TOWN AND COUNTRY PLANNING ACT 1990 FULL

Reference: H11-1009-25 **Date of Decision:** 22nd December 2025
Applicant: Mr & Mrs Lockyer
4 Daniels Gate
Long Sutton
Spalding
Lincolnshire
PE12 9DP
Location: 4 Daniels Gate Long Sutton Spalding
Description: Proposed Sun Room Extension

SCALE as shown at A1
DATE OCT 2025
DRAWN STB
DRAWING NO
350 - 01

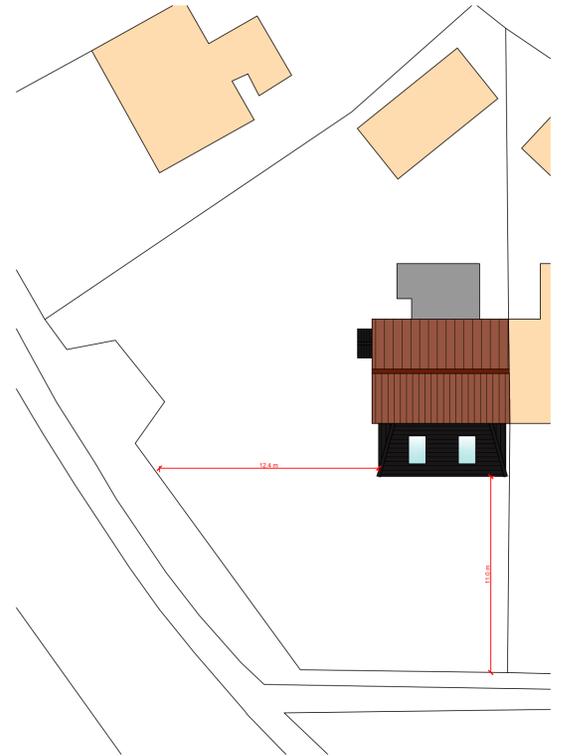
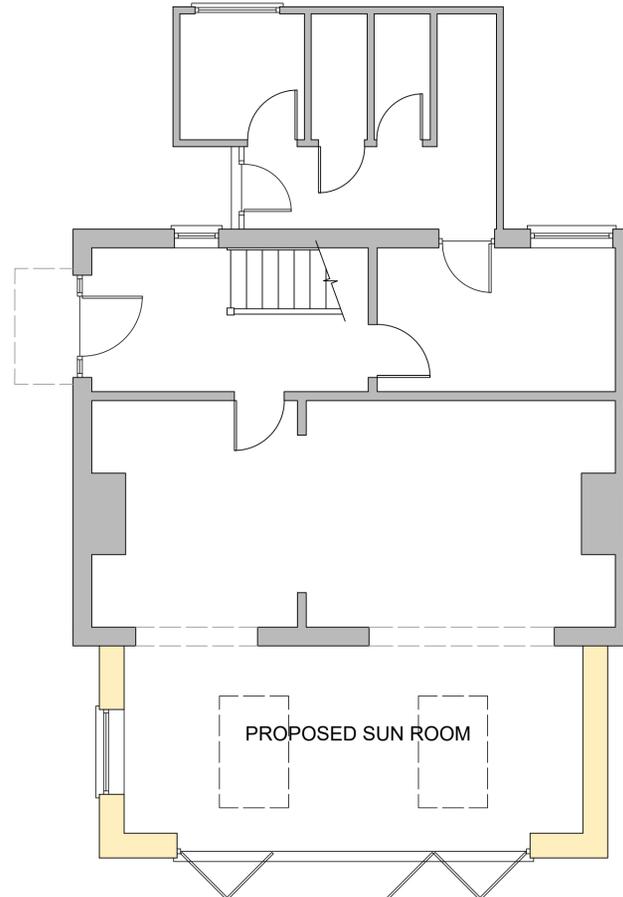
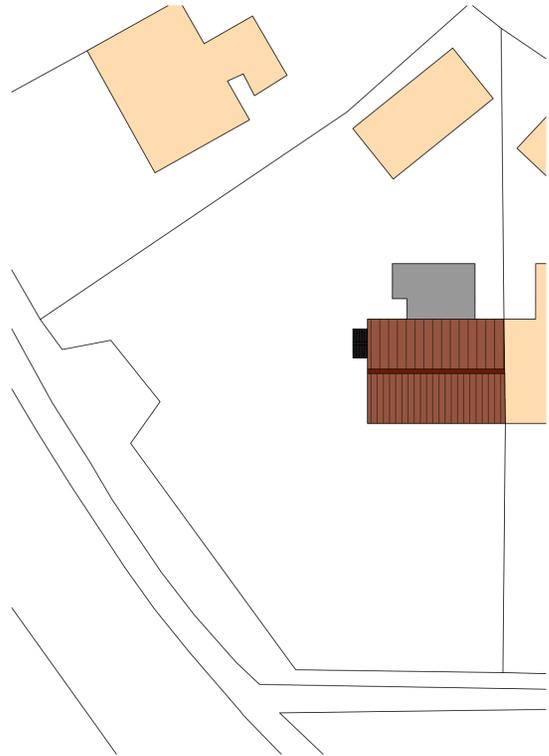
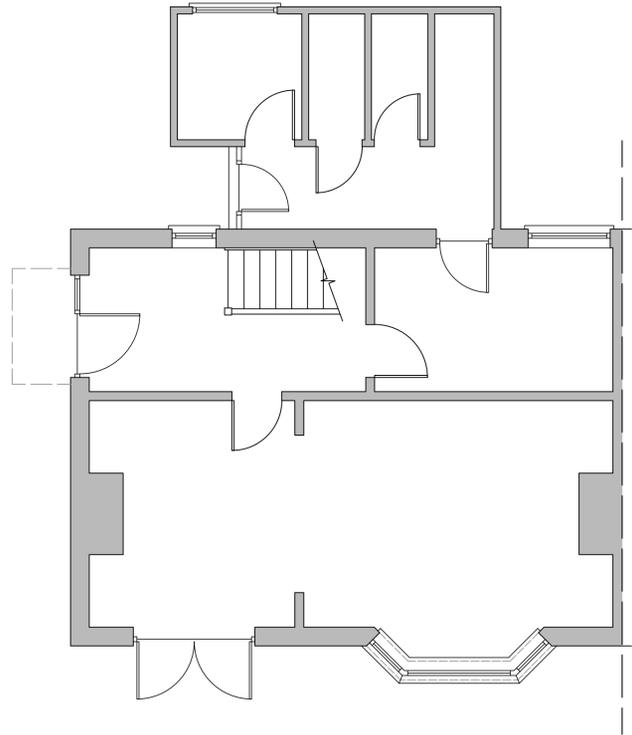
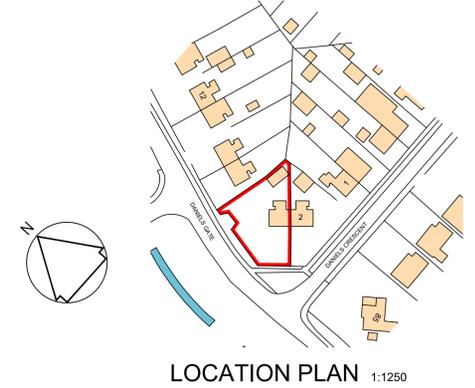
The extension would protrude from the front elevation of the dwelling as outlined within drawing number '350-01'. As such, an extension along this elevation would appear at odds with the wider area and if approved would cause harm to the character and appearance of the locality. Notwithstanding the siting of an existing hedge that spans this

boundary, the Local Planning Authority are unable to reasonably control its retention or maintenance indefinitely by condition.

Therefore, should the extension be permitted and subsequently developed, under the basis the hedge could be removed, the extension would be readily visible and open to the street scene and wider area, which would cause material harm to the area, introducing an atypical feature for a front elevation, particularly within this immediate area, and the extension would cause material harm to the character and appearance of the area.

Therefore, the proposal is not considered to be acceptable, it would cause significant and unacceptable harm to the street scene and locality. The proposal would be at conflict with Policies 2 and 3 of the South East Lincolnshire Local Plan (SELLP, 2019) and Section 12 of the National Planning Policy Framework (December 2024).
